Ribchester Parish Council

PLANNING APPLICATION No: 3/12/0449

Application: Proposed erection of two holiday units, patio garden and garden and extend vehicular access

At: PARK HEY HOUSE, STONEYGATE LANE RIBCHESTER

SOUTH WEST ELEVATION

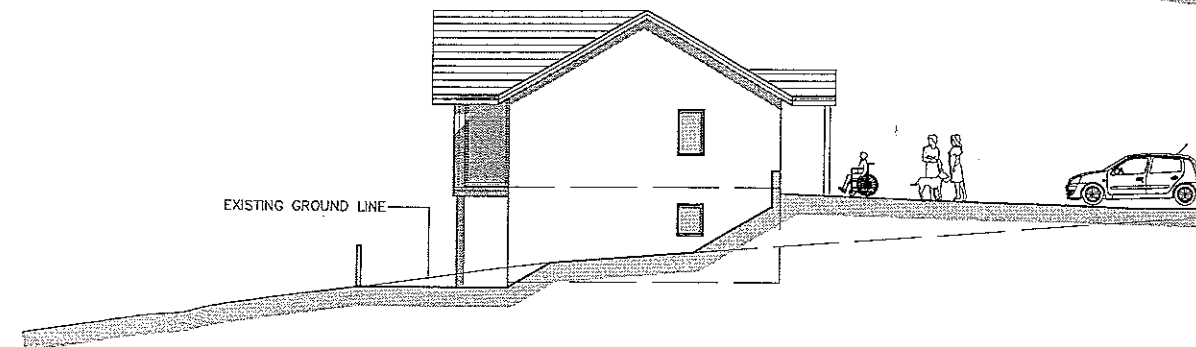
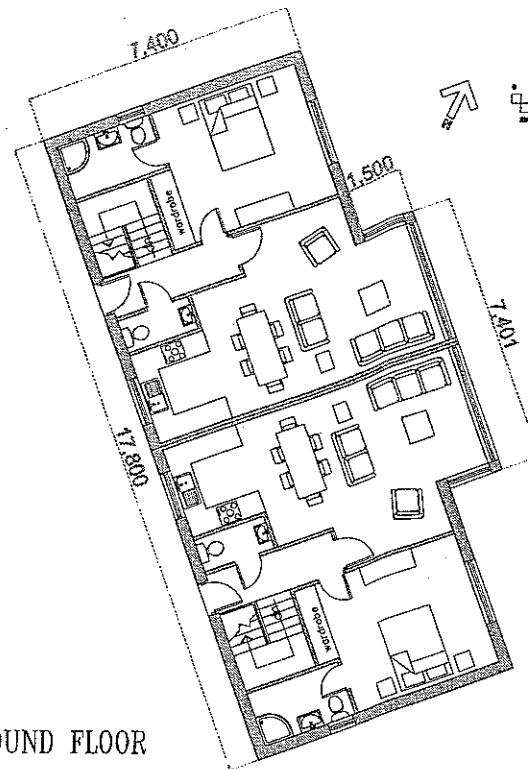
Drawing 107 02A: The canopies depicted on the south West elevation are not included on the ground Floor plan.
